**From:** Nolan, Chris <Chris.Nolan@lancashire.gov.uk>  
**Sent:** 22 November 2017 13:37  
**To:** Harriet McCartney; planning  
**Cc:** LHS Customer Service  
**Subject:** D3.2017.0993 - 22 Shireburn Avenue Clitheroe RD  
**Attachments:** 17 0993 Amendment 22Nov17.pdf

Planning Application No: 3/2017/0993

Proposal: Removal of garage and erection of new integral garage with single storey rear and loft extension.

Location: 22 Shireburn Avenue Clitheroe BB7 2PN

A	Amendment to suit highways requirements	J.L.	21.11
---	---	------	-------

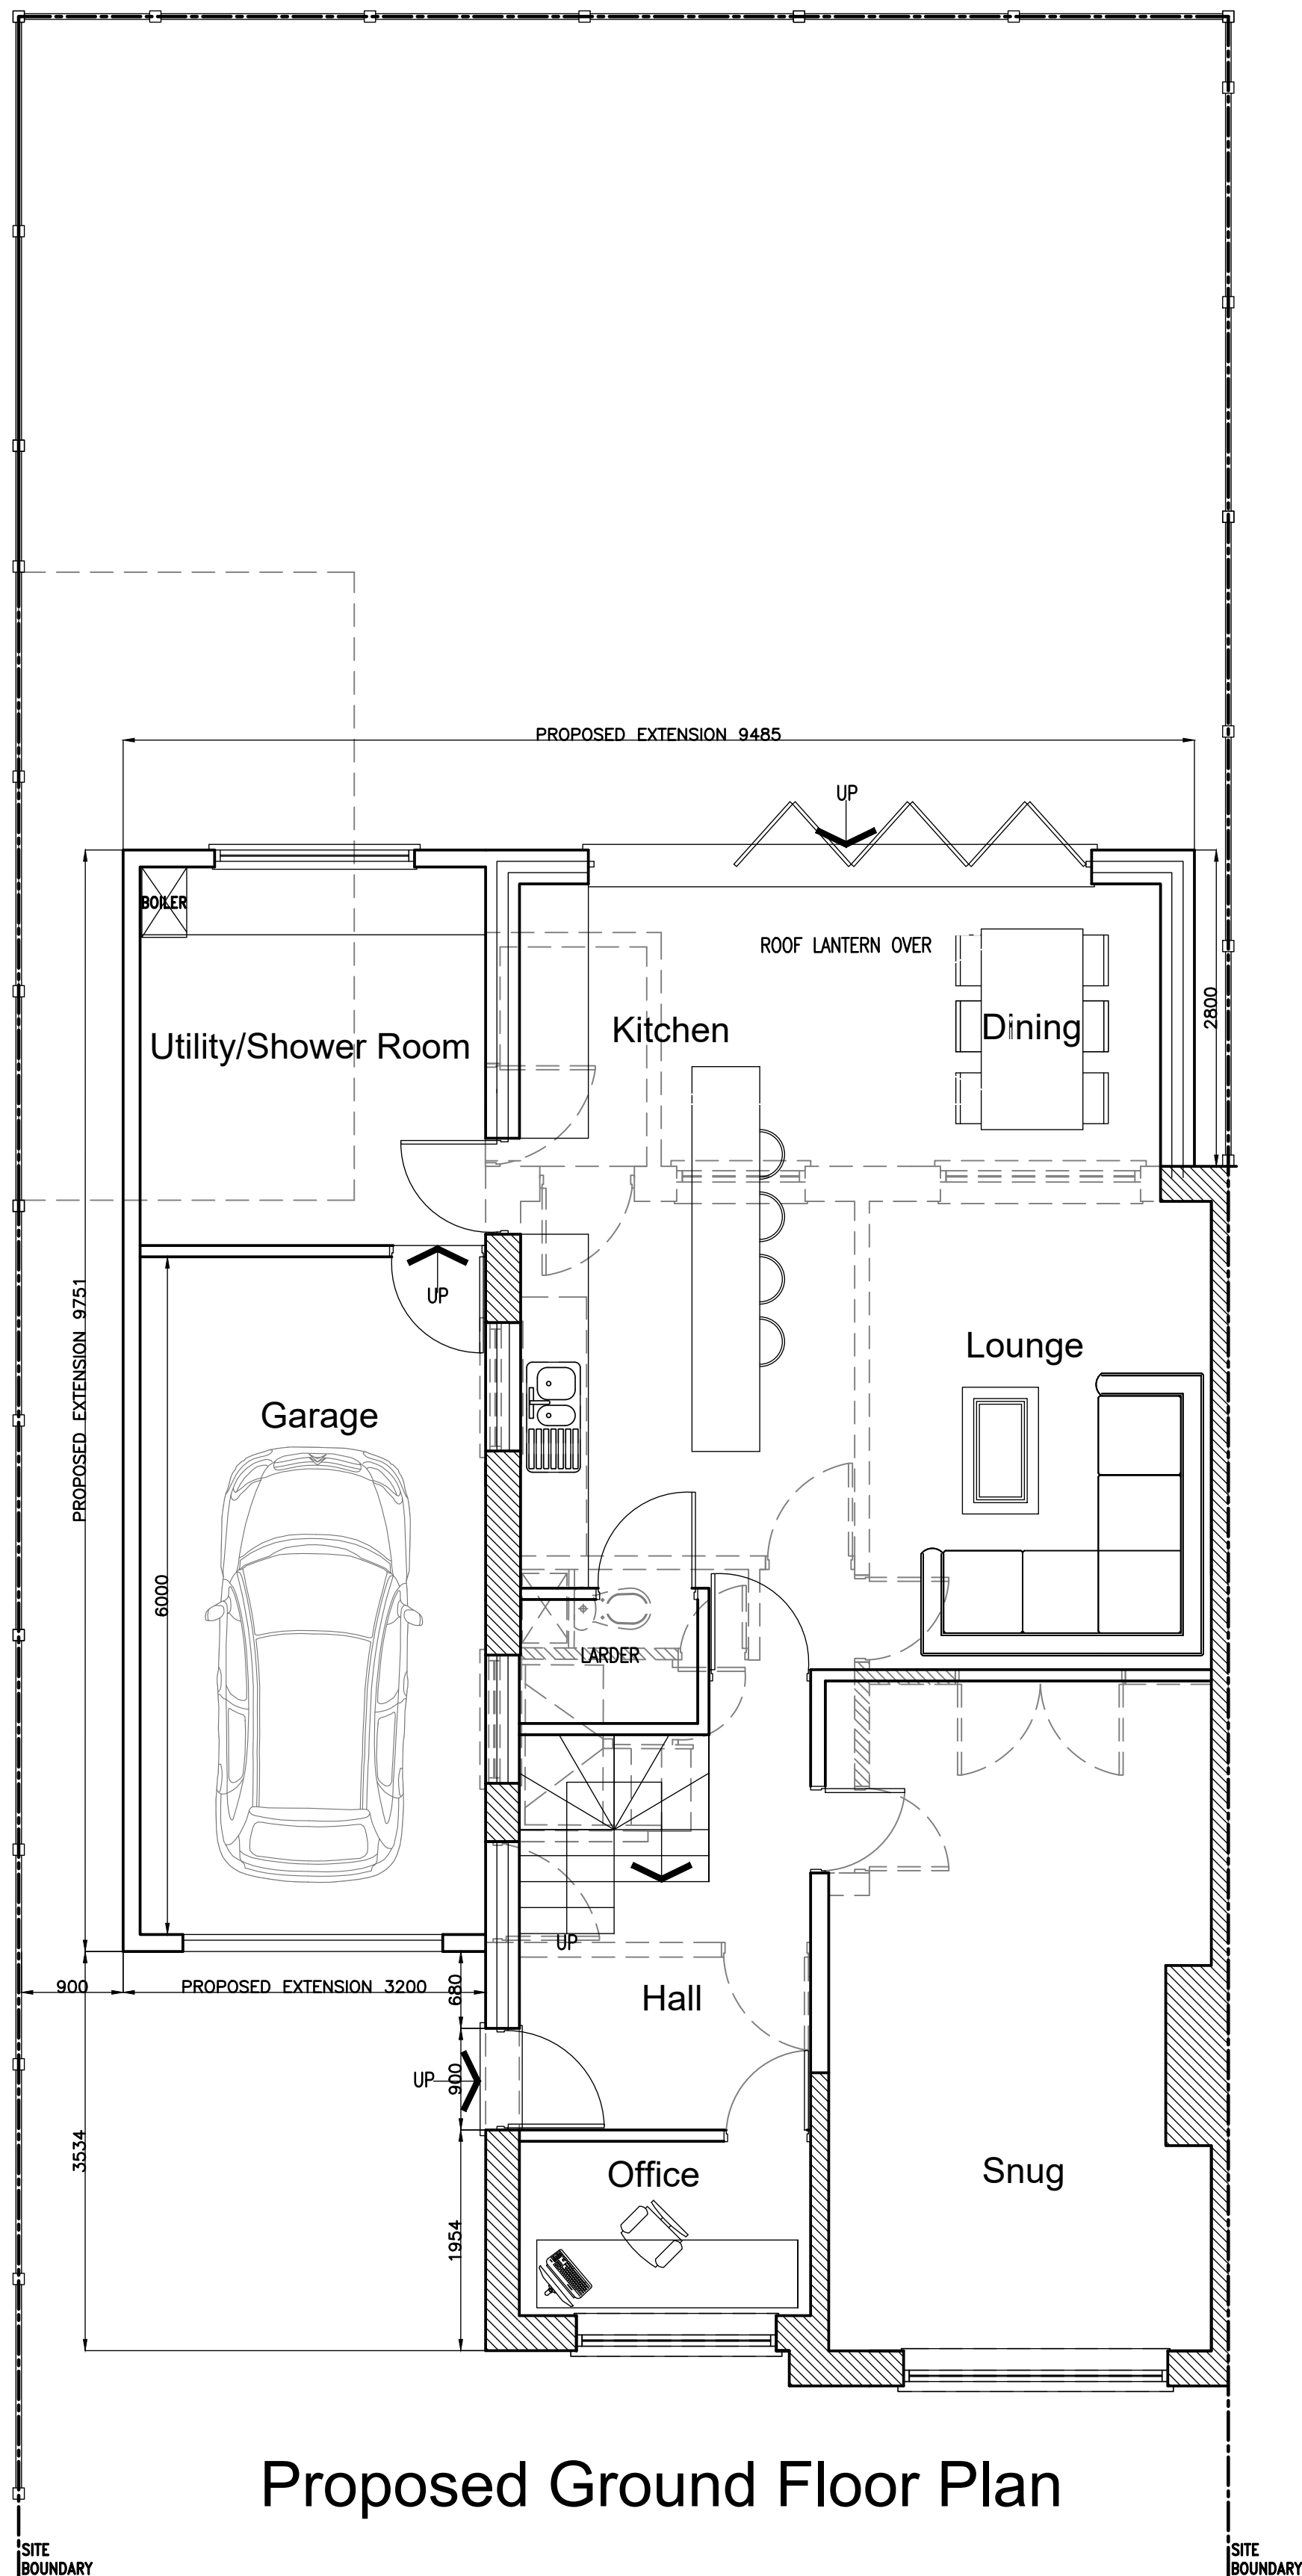
With regard to the above planning application. The attached plan and the amended site plan, as view on the website, would indicate that the site will provide the required parking for a four bedroom dwelling. The application will use an existing vehicle crossing and therefore there will be no need for alterations to the highway. The amended site plan also indicates that there will be space to store the household refuse at the rear of the building with a walkway to allow the bins to be placed at the front of the property for collection. In light of the new information, I would remove my objections to the application.

Proposed Site Plan

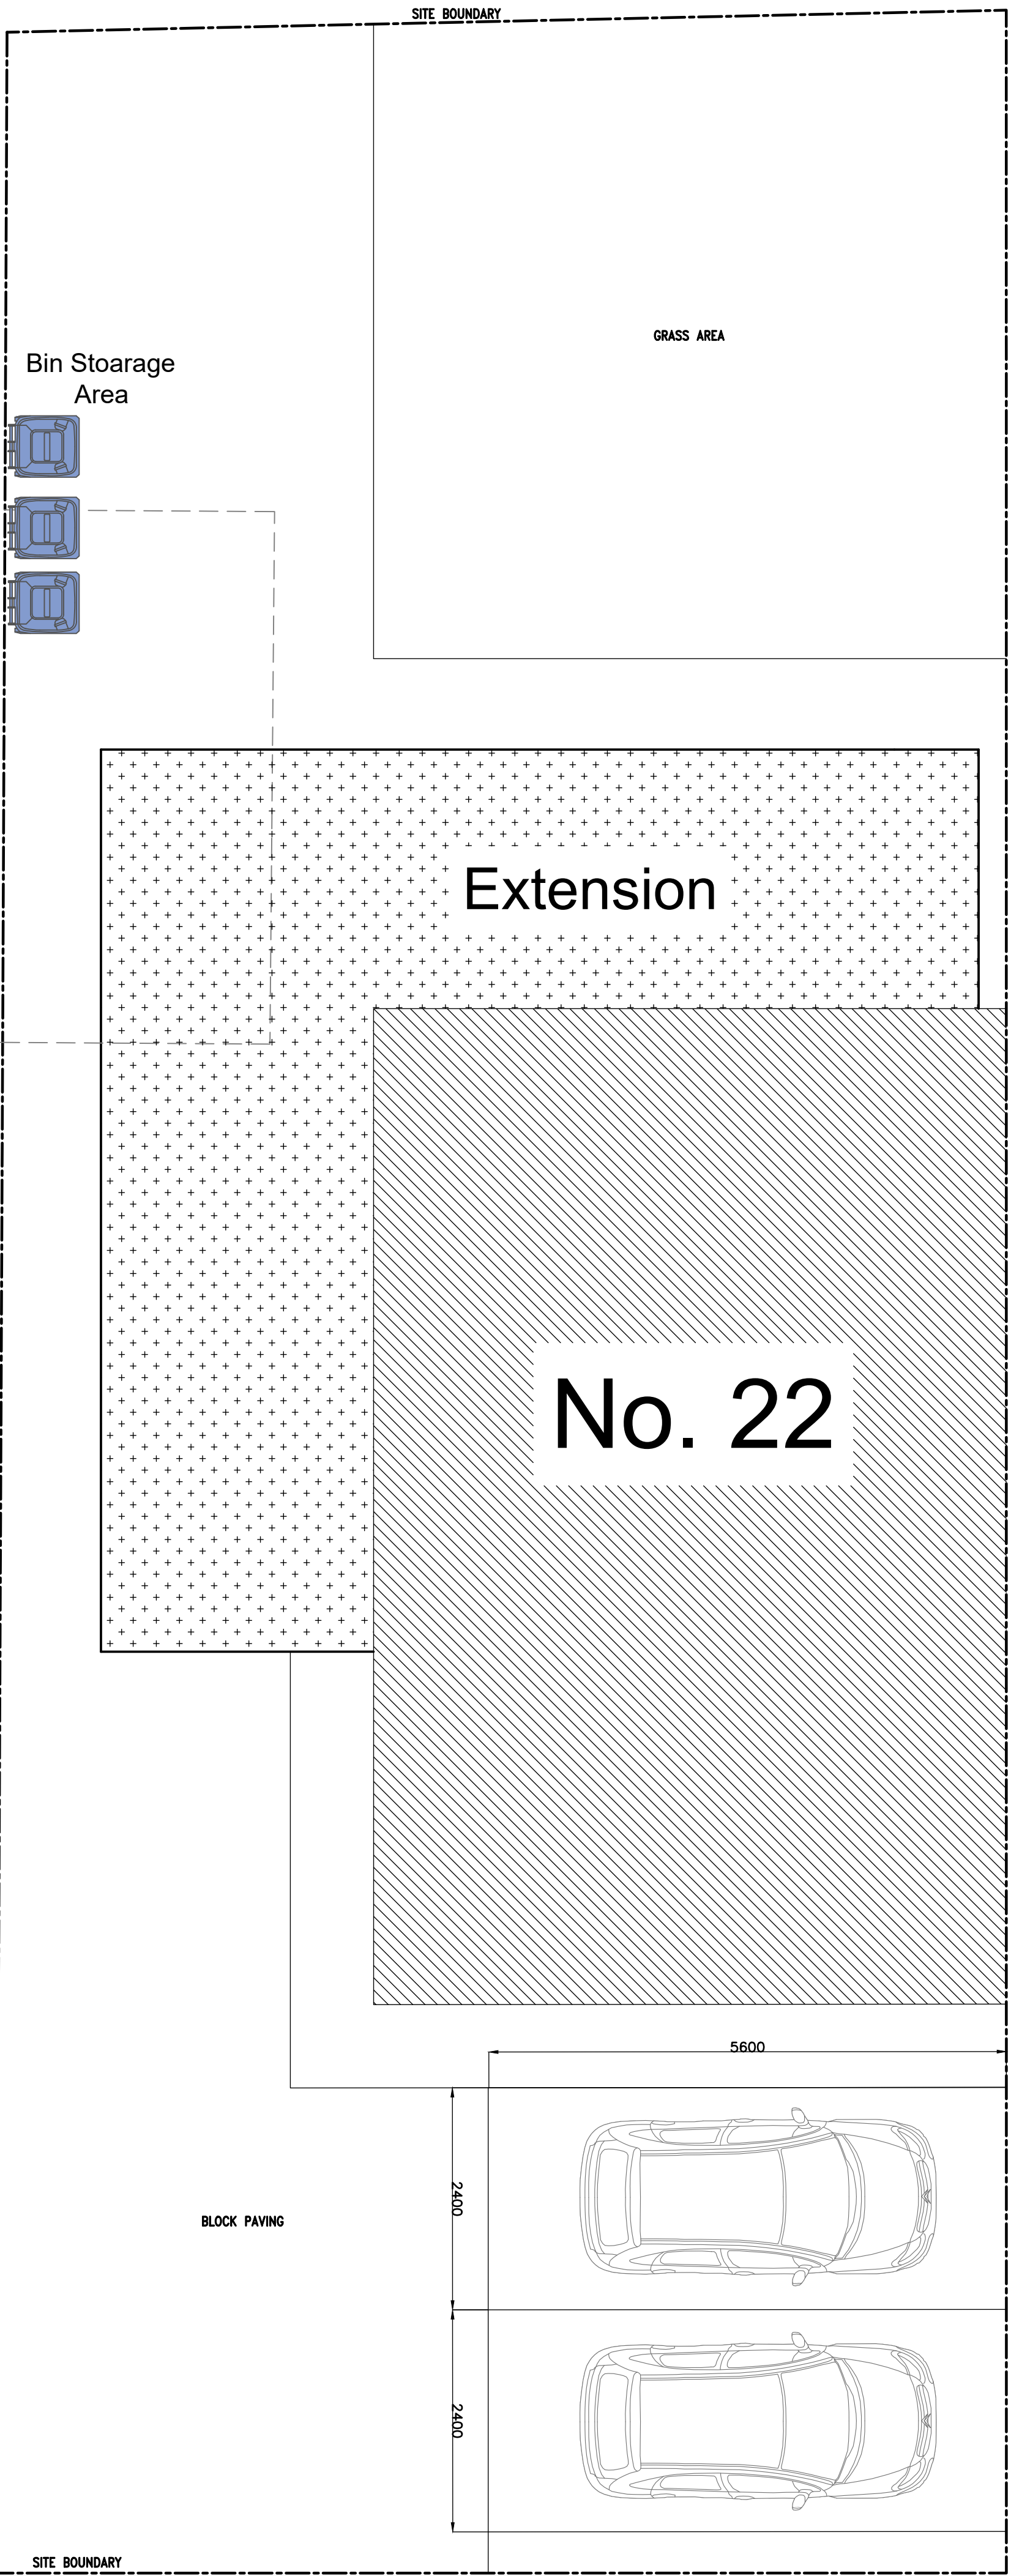
1. Before the access is used for vehicular purposes, that part of the access extending from the highway boundary for a minimum distance of 5m into the site shall be appropriately paved in tarmacadam, concrete, block pavements, or other approved materials. Reason: To prevent loose surface material from being carried on to the public highway thus causing a potential source of danger to other road user.
